Your Reference: 08_0200 (MOD 3)

14 August 2014

**Comments on the proposed modification of the Cobaki Central
Open Space Project Approval (MP08_0200 Mod 3)**

TITLE					
EROSION & SEDIMENT CONTROL PLAN					
SHEET 1 OF 2					
TASK	BY	INITIAL	DATE	APPROVED	RPEQ No
REVIEW					
DESIGN					
DRAWN					
				DRAWING NUMBER	REVISION
				YC0229-1E1-E01	G

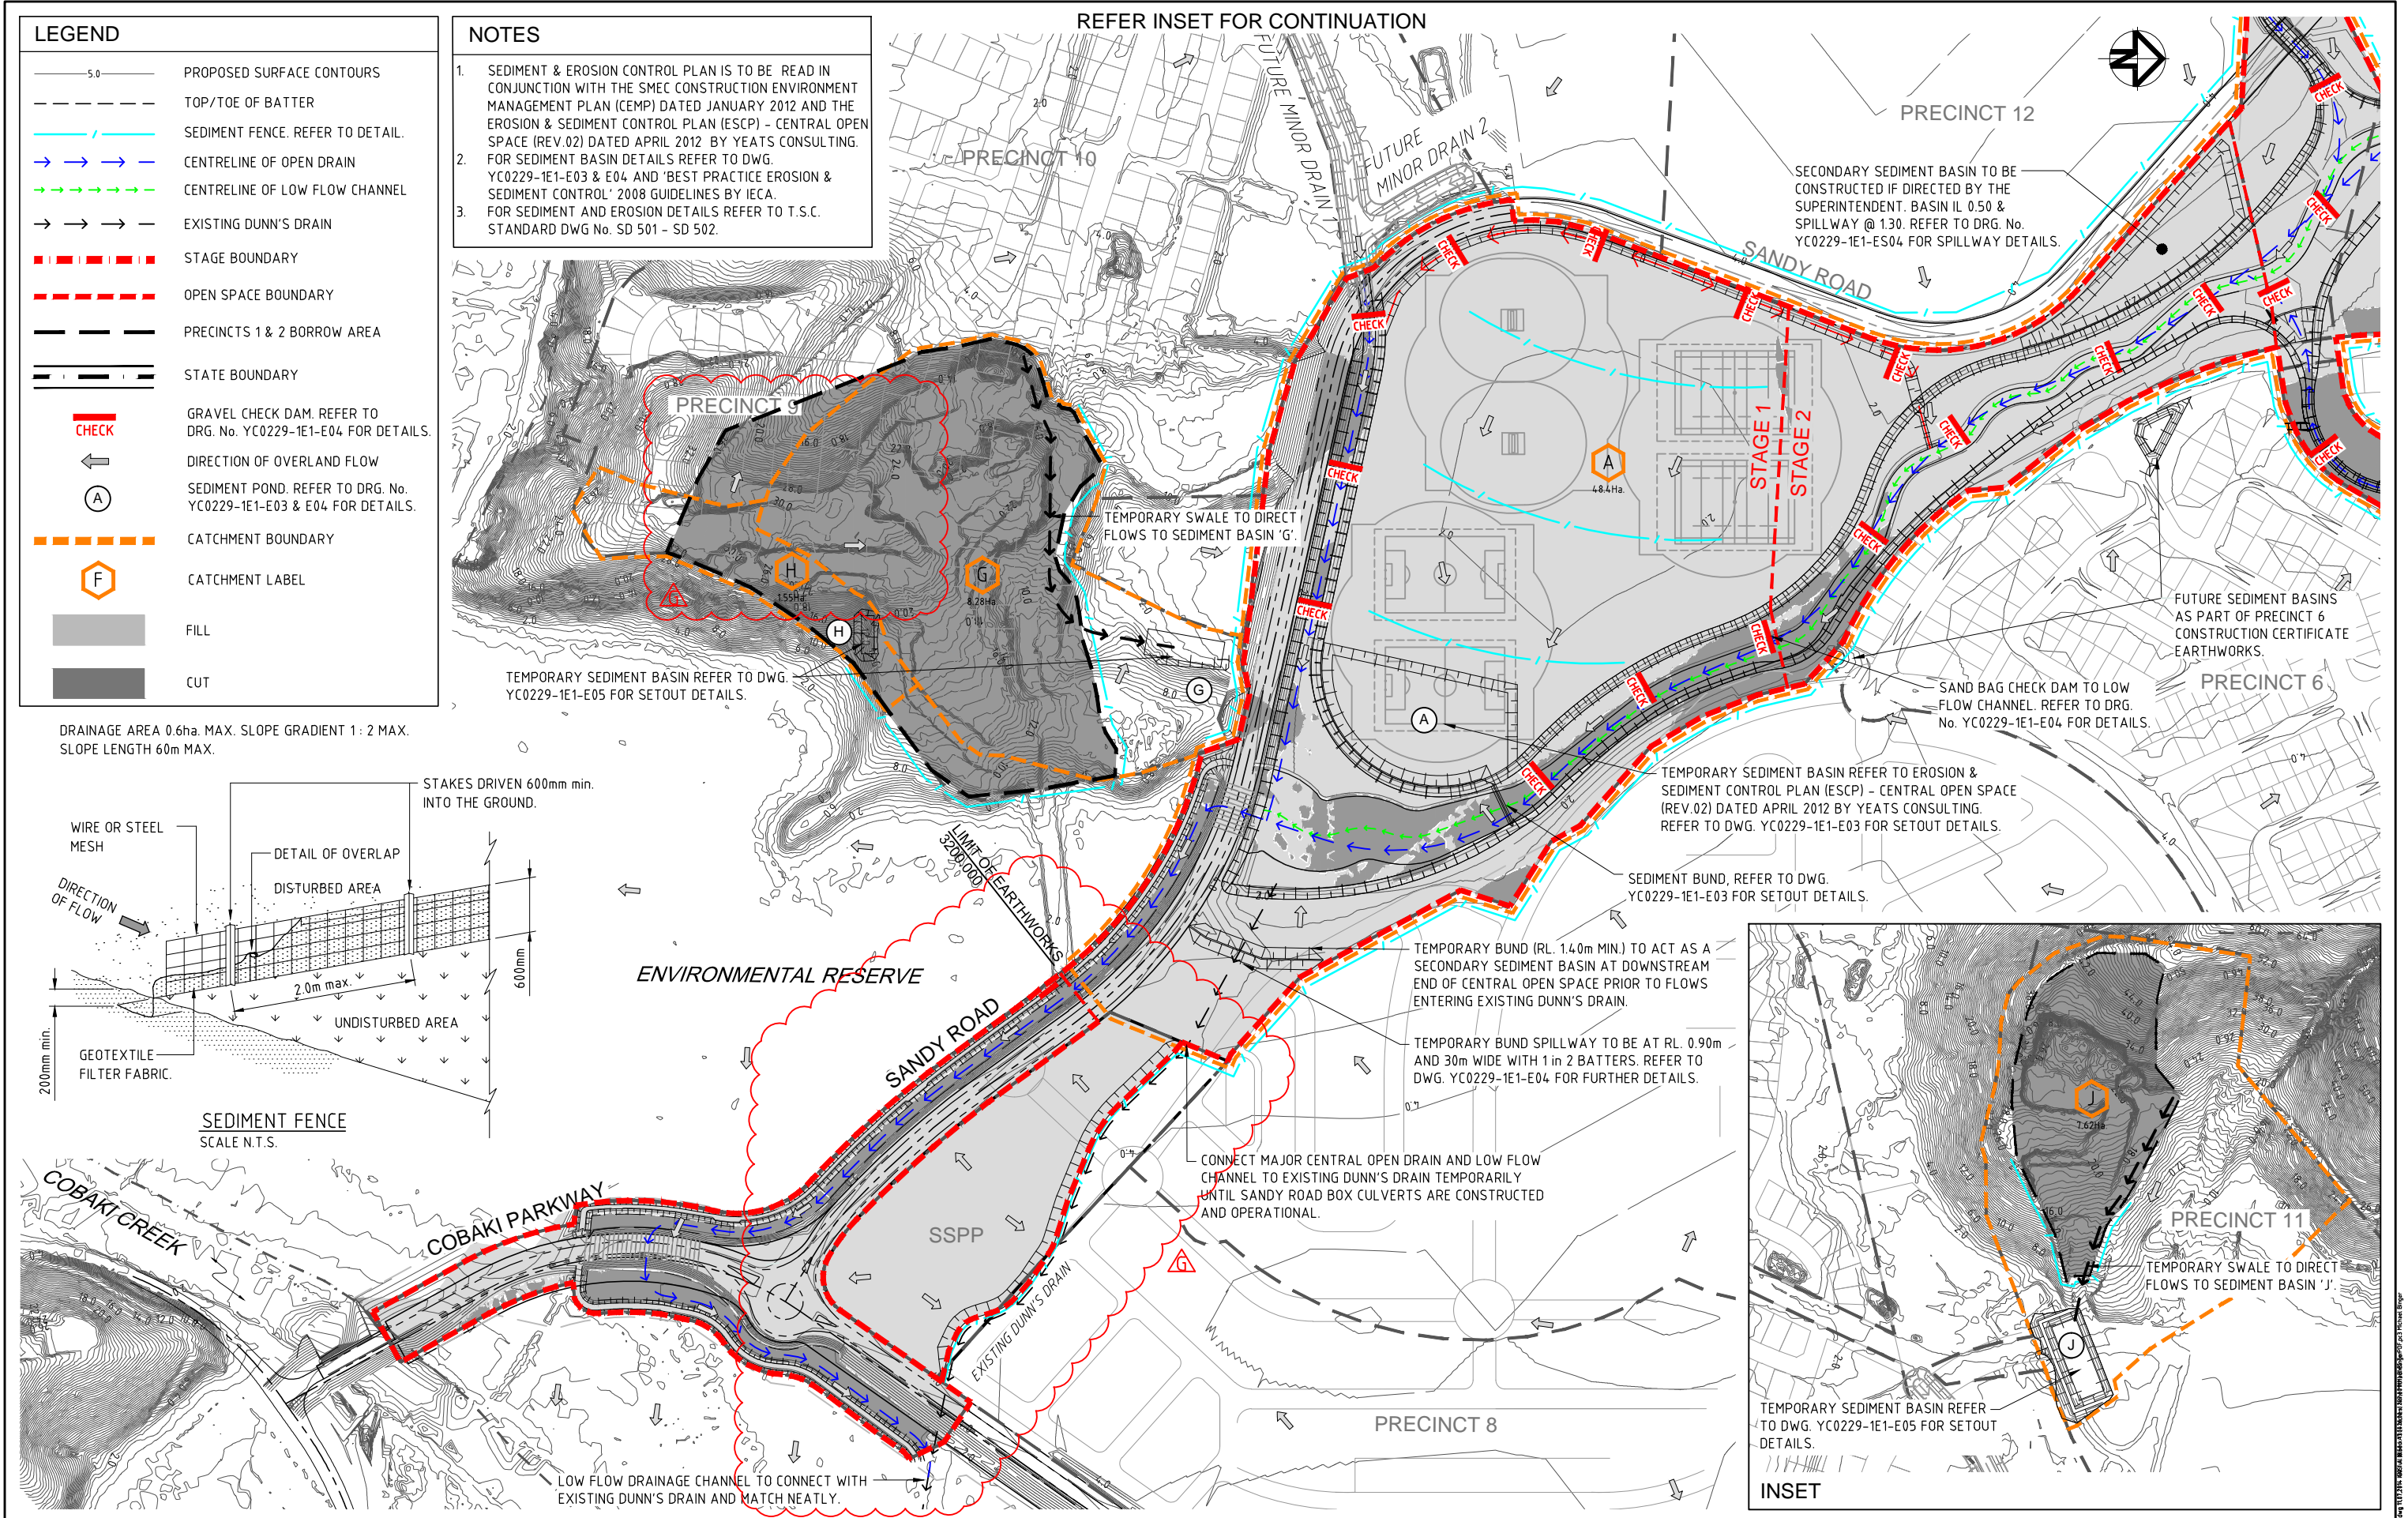
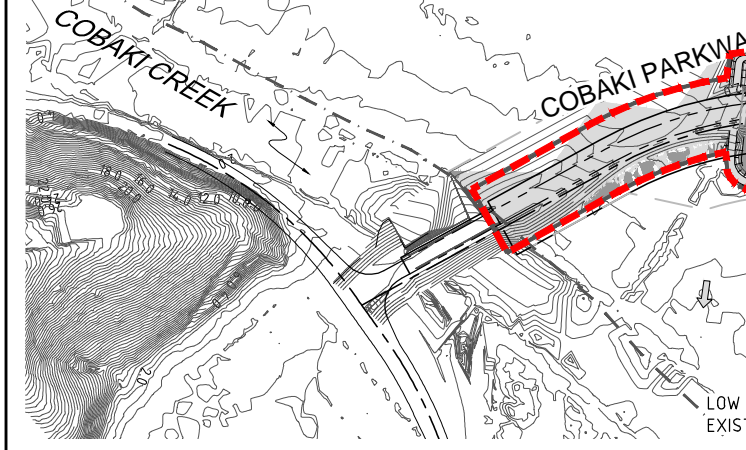
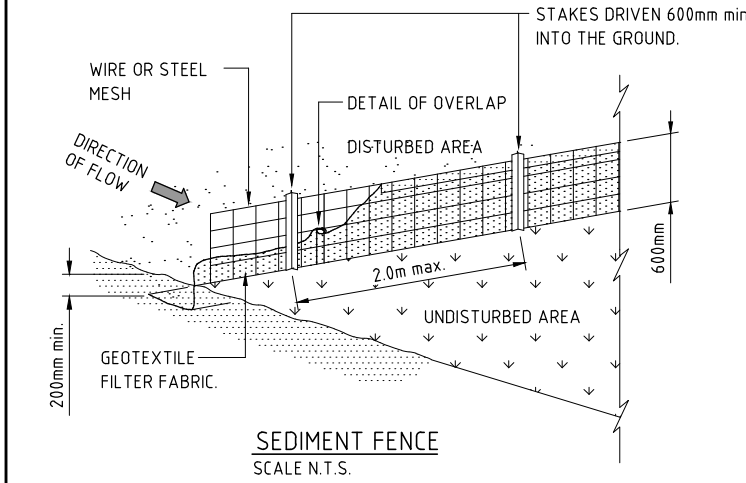
- **YC0229-1E1-E01 Rev G - Erosion & Sediment Control Plan Sheet 1 of 2 - Date 30.06.14**
 - YC0229-1E1-E01 was previously added by Mod 1 (Rev C) and amended under Mod 2 (Rev F).

- This proposed, amended plan is supported, however it should be clarified if YC0229-1E1-E01 G replaces YC0229-1P1-E01 B which was approved under MP08_0200.

INDEX SHEET					
TASK	BY	INITIAL	DATE	APPROVED	RPEQ No
REVIEW	CS		18.03.11		
DESIGN	CJE		18.03.11		
DRAWN	GS		18.03.11		
DRAWING NUMBER				YC0229-1E1-D02	REVISION
					H

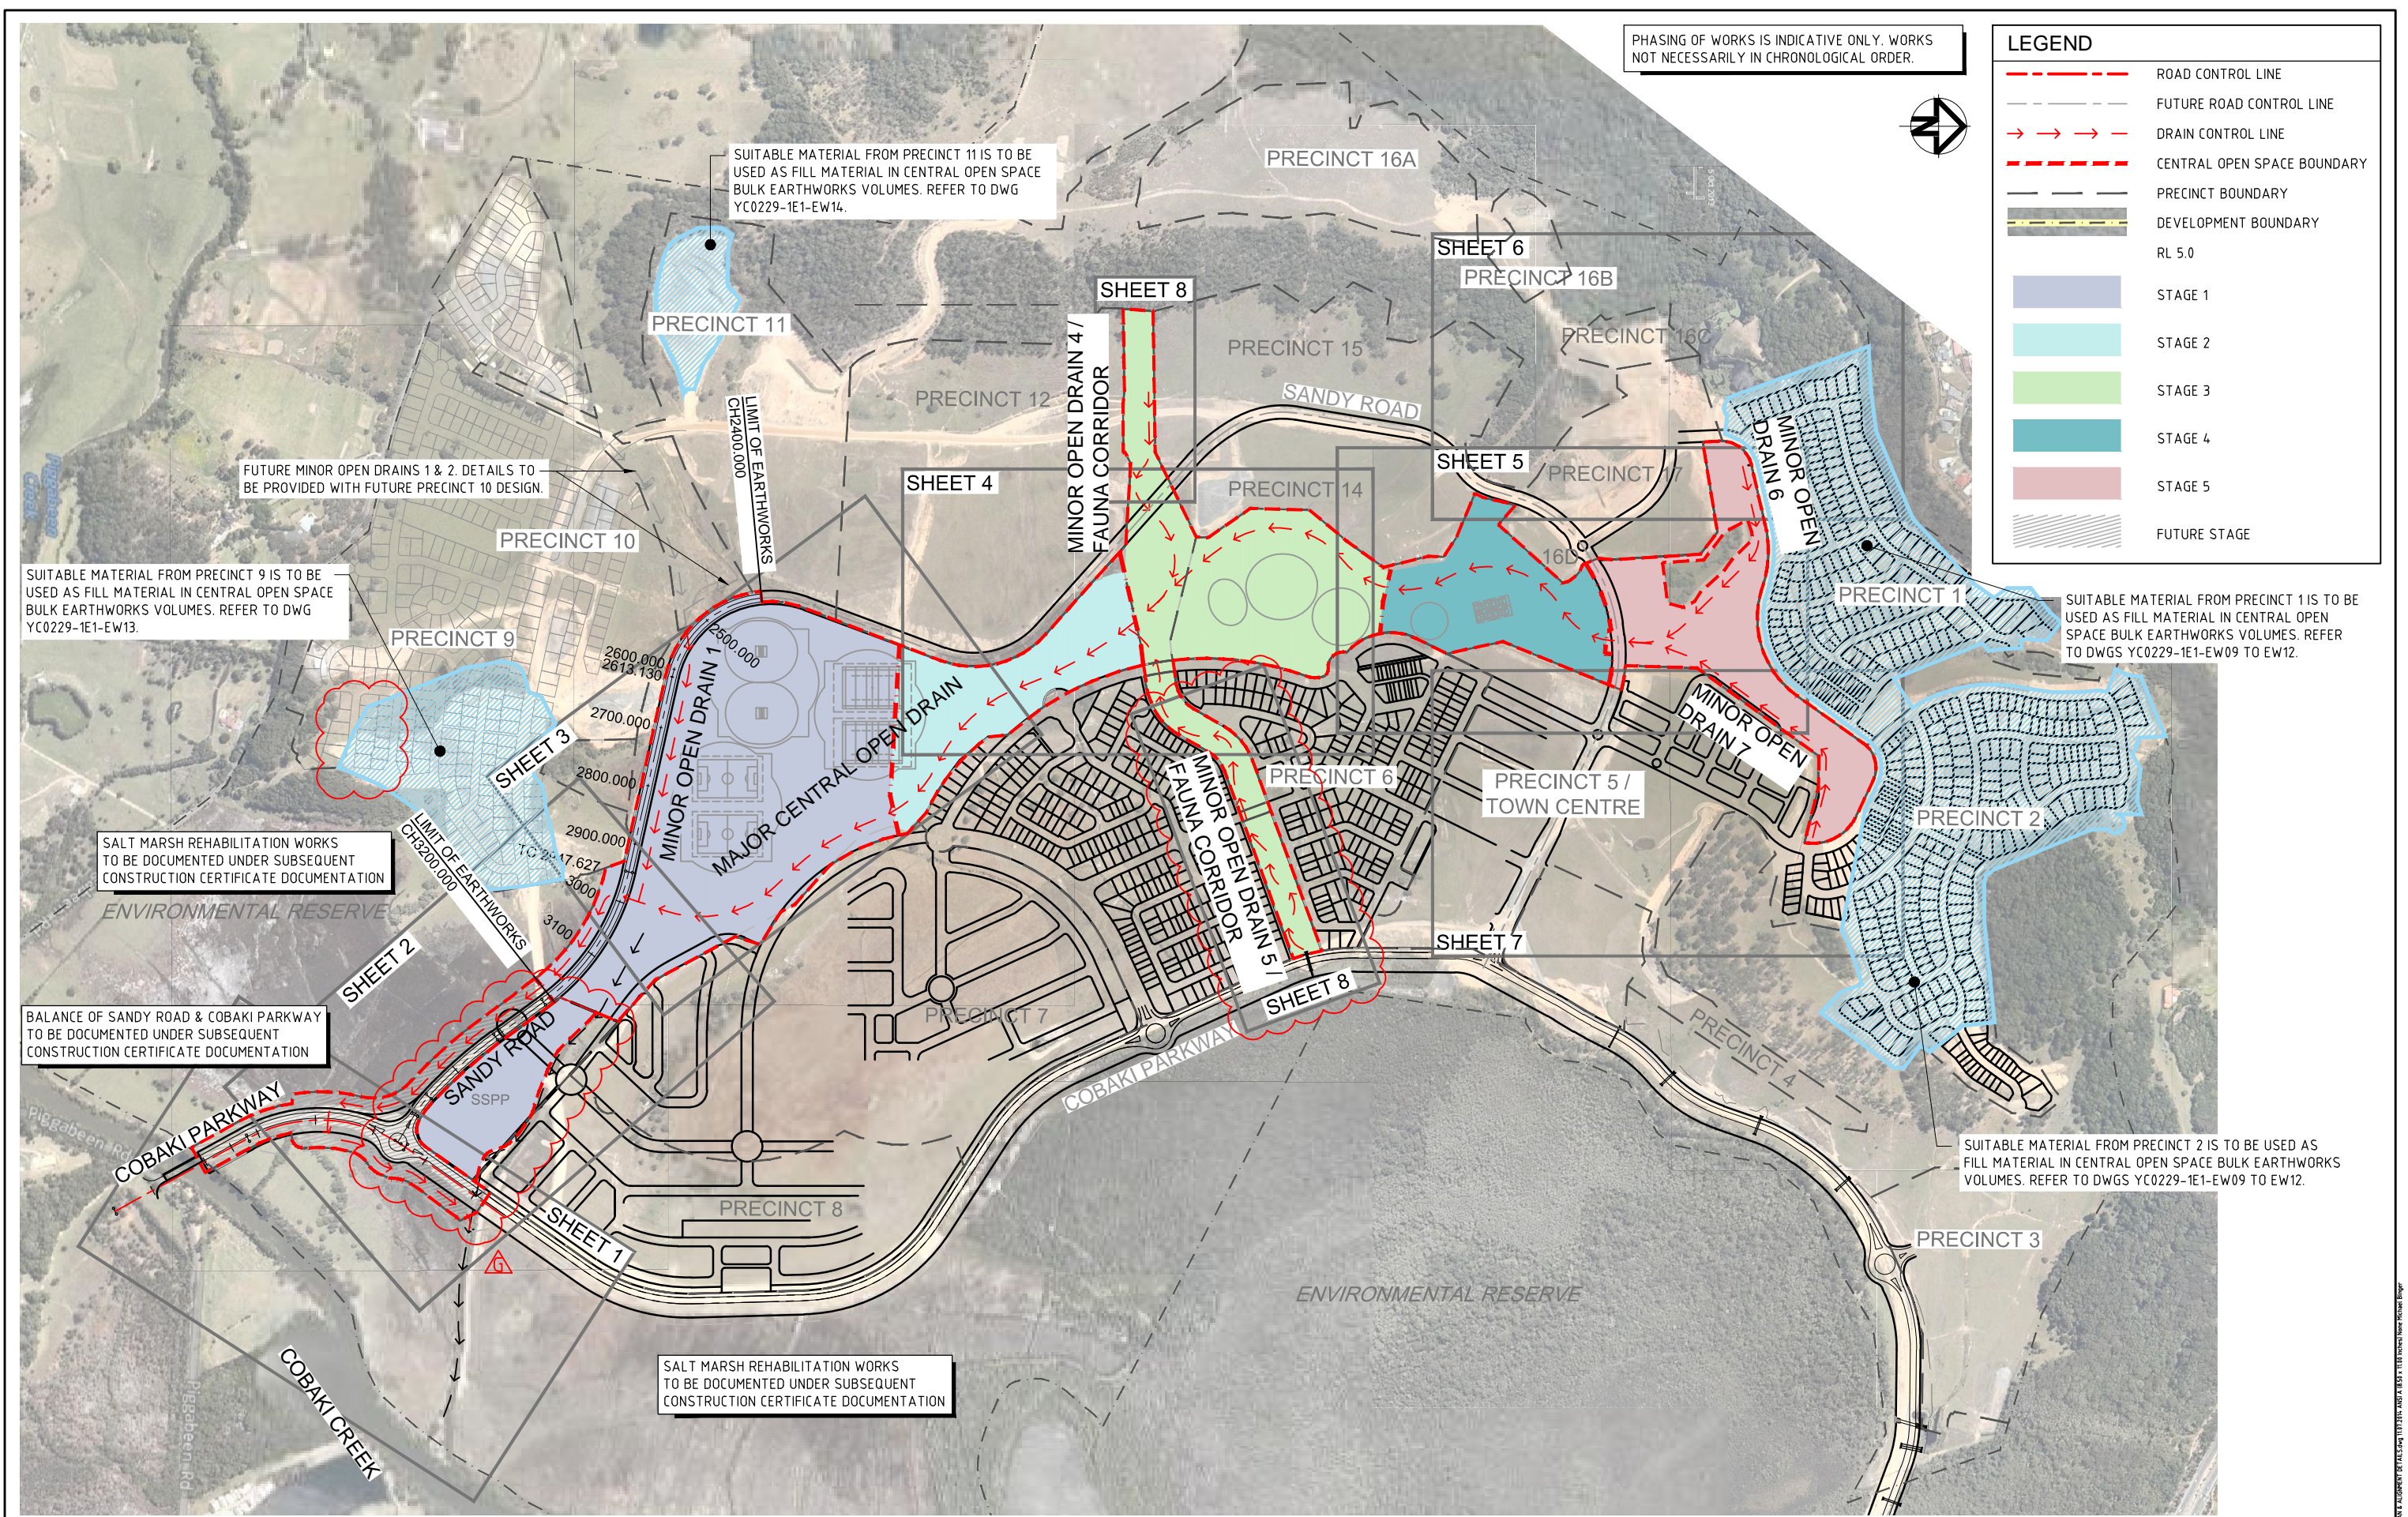
- **YC0229-1E1-D02 Rev H – Index Sheet - Date 30.06.14**
 - YC0229-1E1-D02 H is proposed to be added to the Consent (for the first time) by Mod 3.
 - YC0229-1E1-D02 H references a significant number of unapproved plans and the modification needs to take this into consideration before it is considered further - refer to additional comments on plans below.

- It should also be clarified if YC0229-1E1-D02 H replaces YC0229-1P1-D02 C which was approved under the original MP08_0200.
- **YC0229-1E1-D03 Rev G - Scope of Works & Key Sheet Plan - Date 30.06.14**

An assessment of all the plans shown on the proposed Index sheet for Mod 3 (YC0229-1E1-D02 Rev H – Index Sheet - Date 30.06.14) has been undertaken with the following comments made:

- **YC0229-1E1-D01 D**
 - Council is not aware of YC0229-1E1-D01 D ever being approved.
 - YC0229-1P1-D01 B was approved under MP08_0200, but never YC0229-1E1-D01 D (note the ...1P1... set of plans are different to the ...1E1... set of plans). This inconsistency occurs regularly in proposed YC0229-1E1-D02 H.
